**Consultation Response from KC,
Highways Development Management****2023/90256 Shaley Farm, Shaley, Sandy Gate, Scholes, Holmfirth, HD9 1RY****Demolition of existing building and erection of new dwelling to be used as a holiday let****Date Responded: 26/04/2023.****Responding Officer: D. Stainsby****Responding Ref: K12-4/13**

This application is for the demolition of an existing building and the erection of new dwelling to be used as a holiday let within an existing farm with an access on to Sandy Gate.

Proposed site plan (1:250)

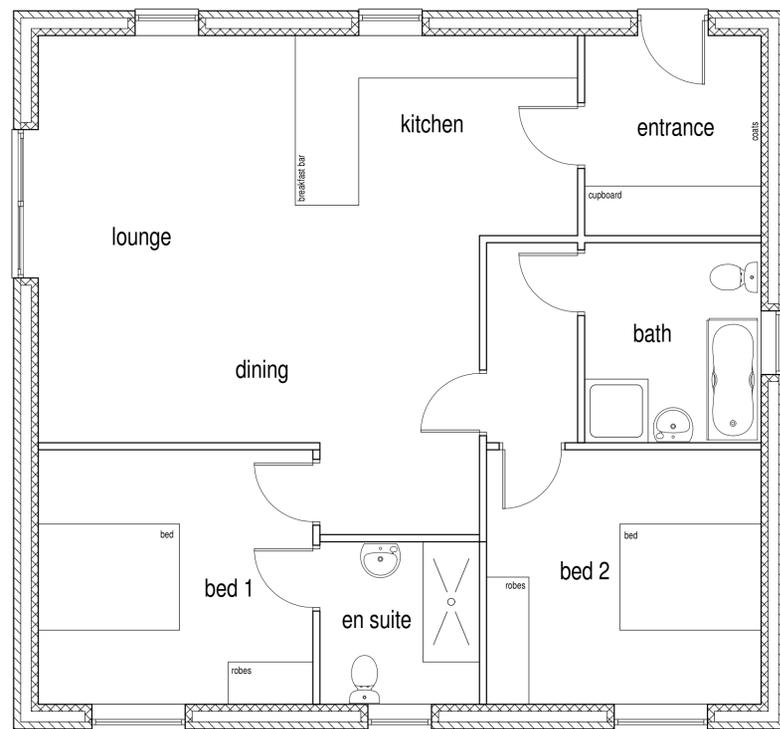
2 car parking spaces are proposed which meet the recommended parking standards for a two bedroomed dwelling.

The approved vehicle parking areas will need to be surfaced and drained in accordance with the Communities and Local Government; and Environment Agencies 'Guidance on the permeable surfacing of front gardens (**parking areas**)' published 13th May 2009 (ISBN 9781409804864) as amended or superseded.

The access and driveway remain as existing,
